PRE-APPLICATION REVIEW TEAM (PRT) DISCUSSION

PRE-APPLICATION REVIEW TEAM (PRT) MEETING NOTES

PA# 18-142 Date: 6-5-18 Time: 2:30 pm

REQUEST: Assisted living + memory care facility -
≈ 78,000 SF, 3-story, w- 75 Beds

**A1 SITE PLAN**  
1" = 20'-0"

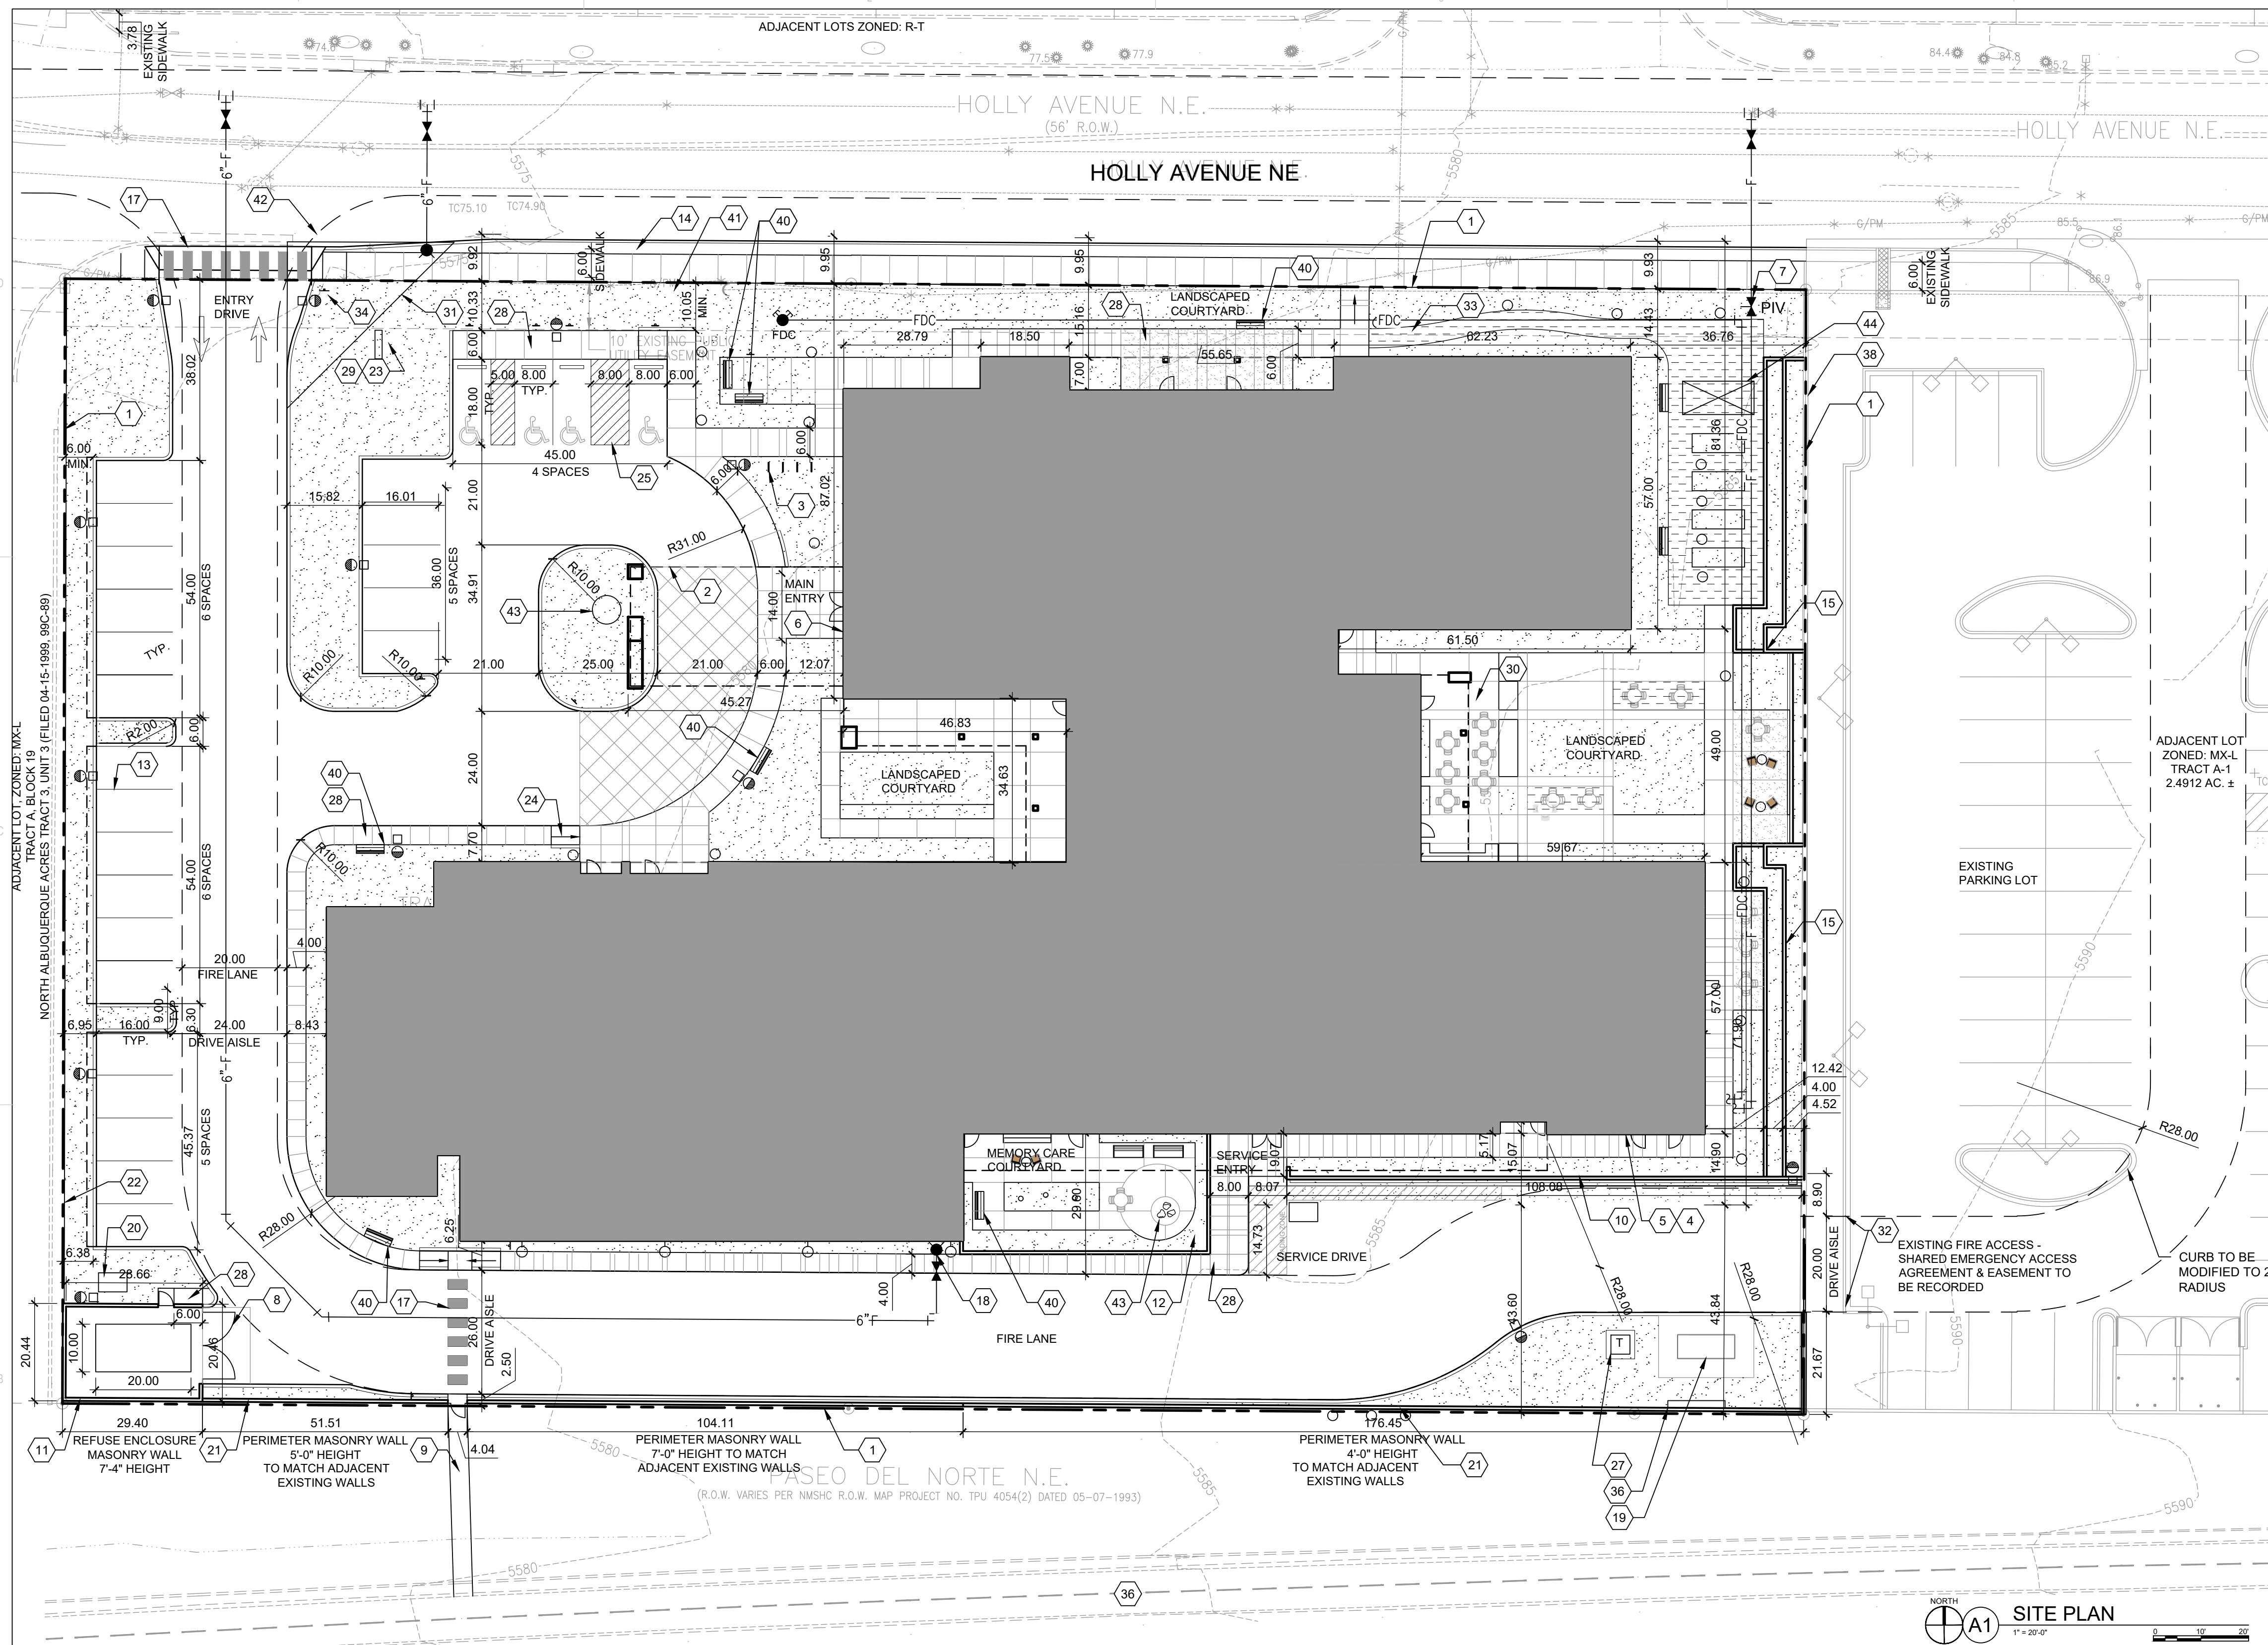
• courtyard faces parking lot and no pathways

• eliminate lot line

• existing curb cut to west encroaches onto lot

**FIRE ACCESS PLAN**  
1" = 20'-0"

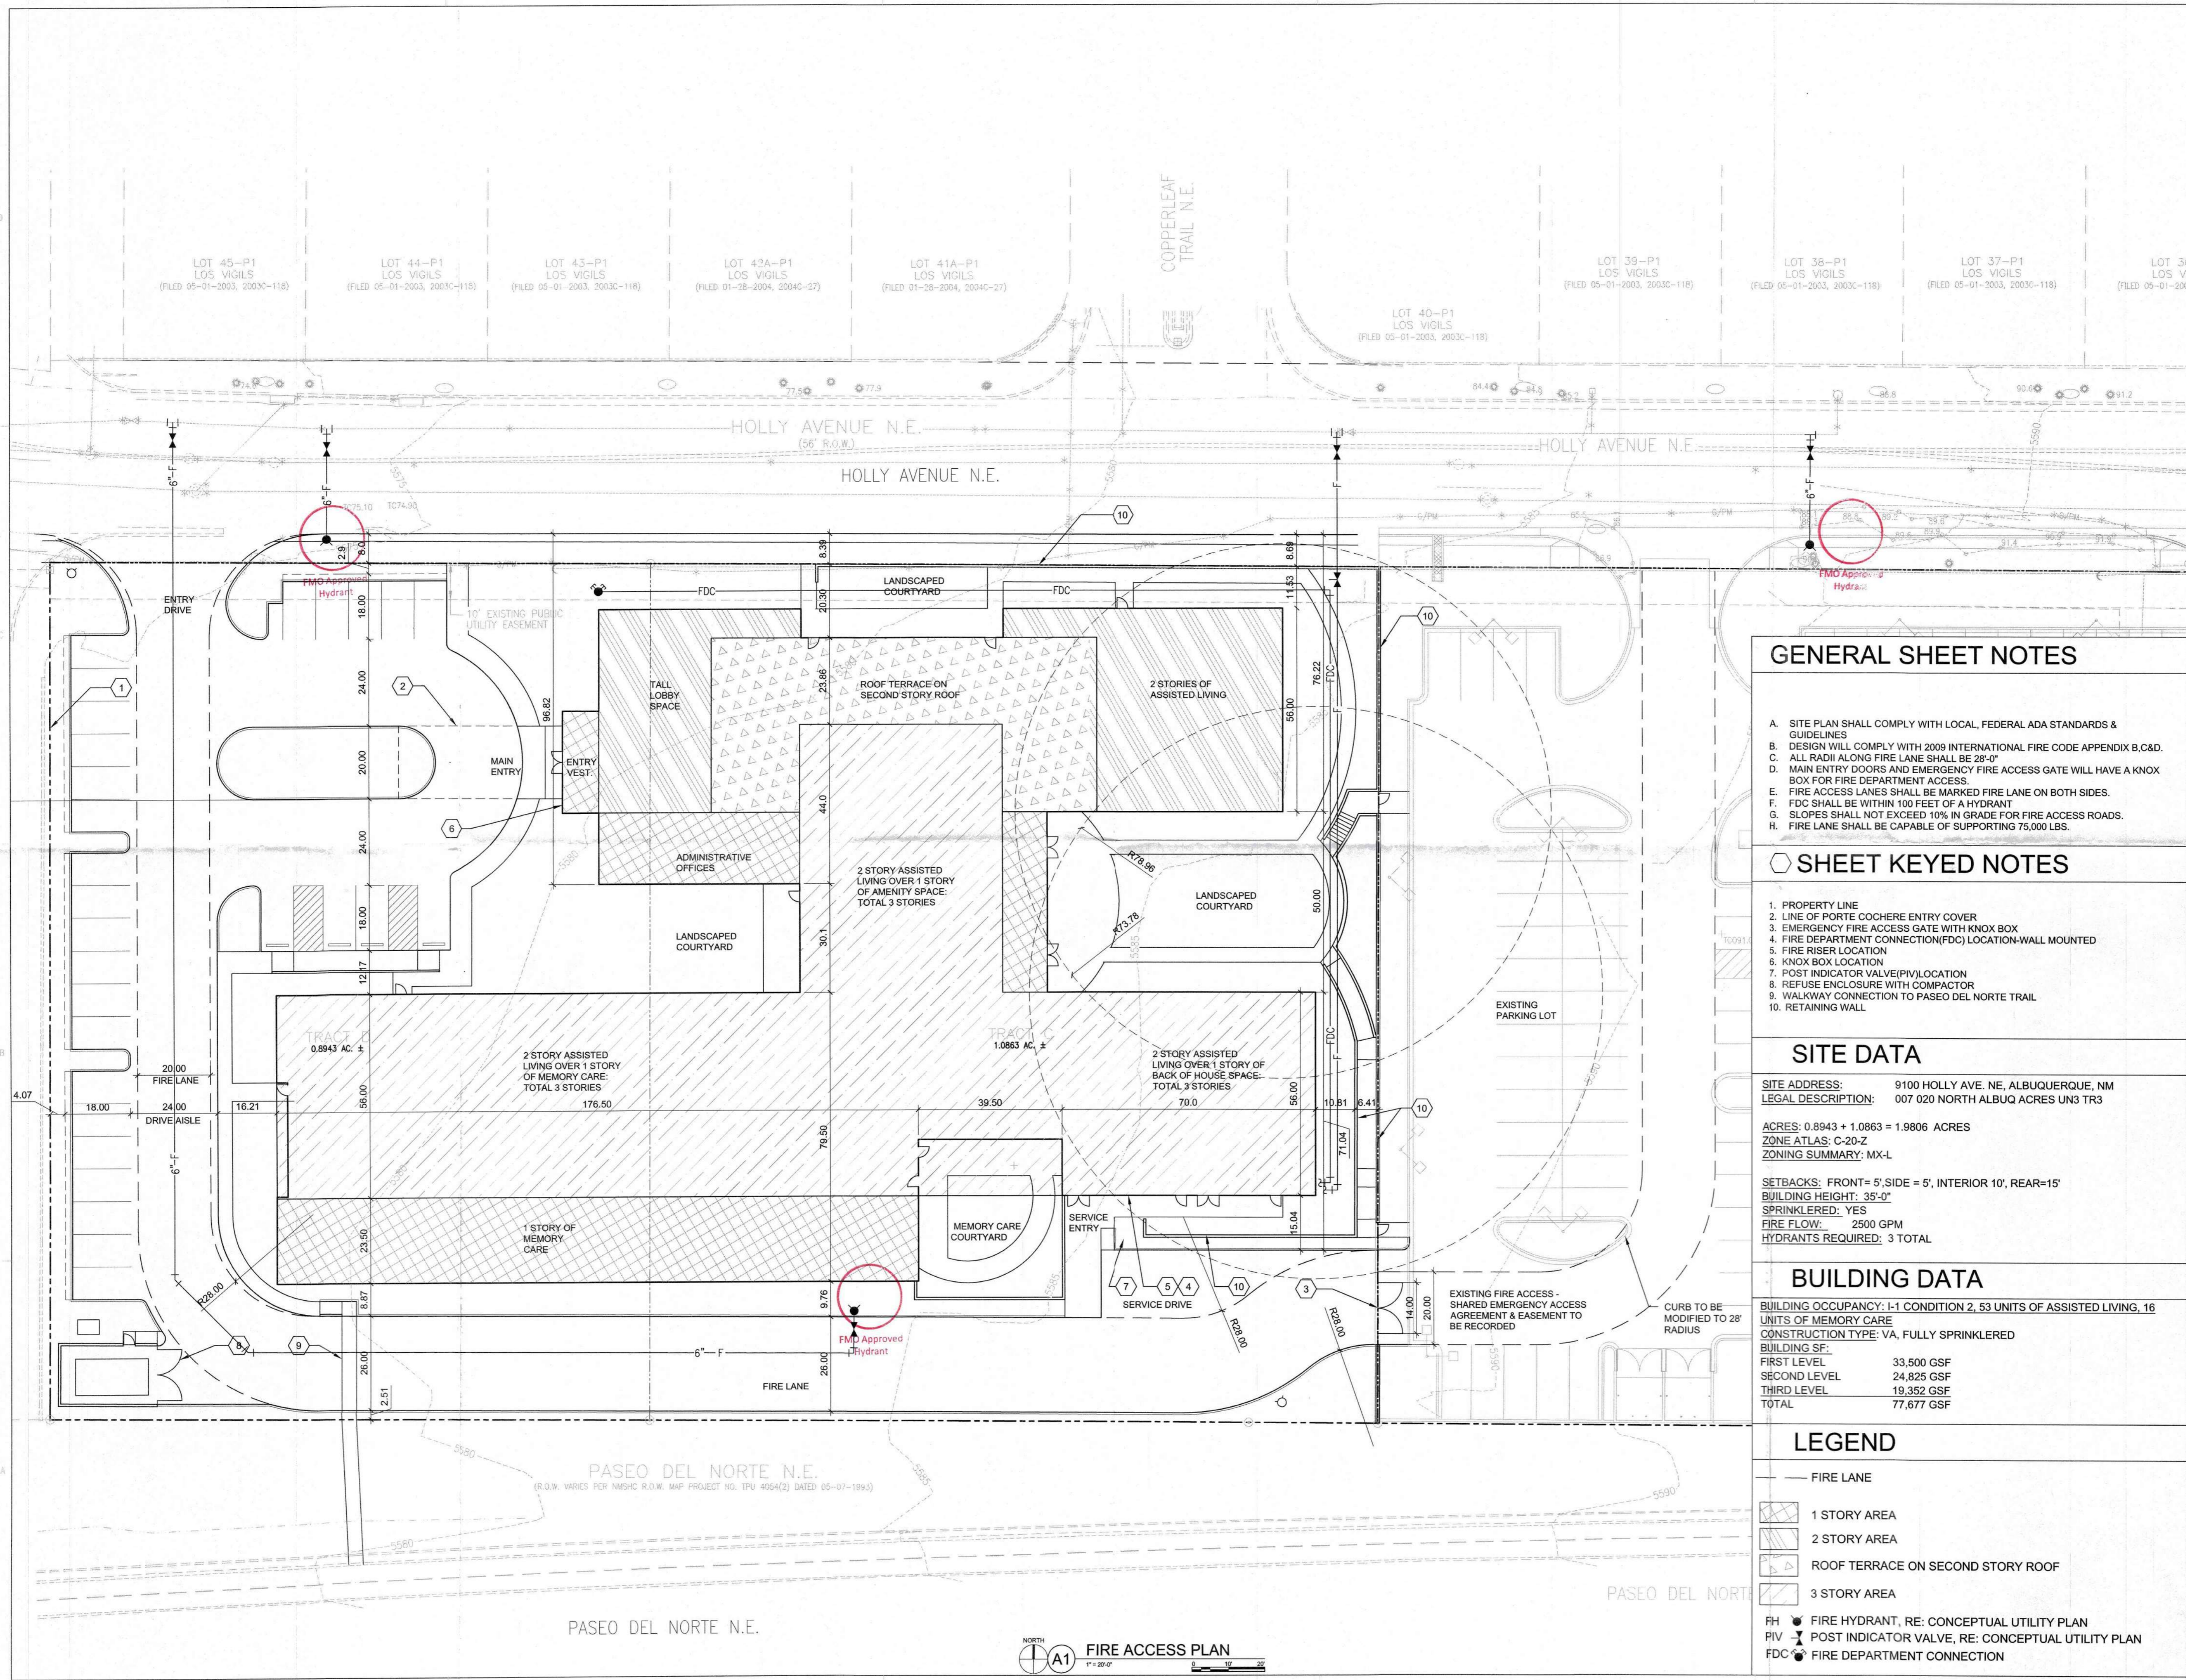
Fire • needs easement to adjacent property

• must be 26' min - Bldg > 30 feet Fall

• w/in 15 feet, max 30 feet:

• sprinkler system required • turn in Fire I ASAP.
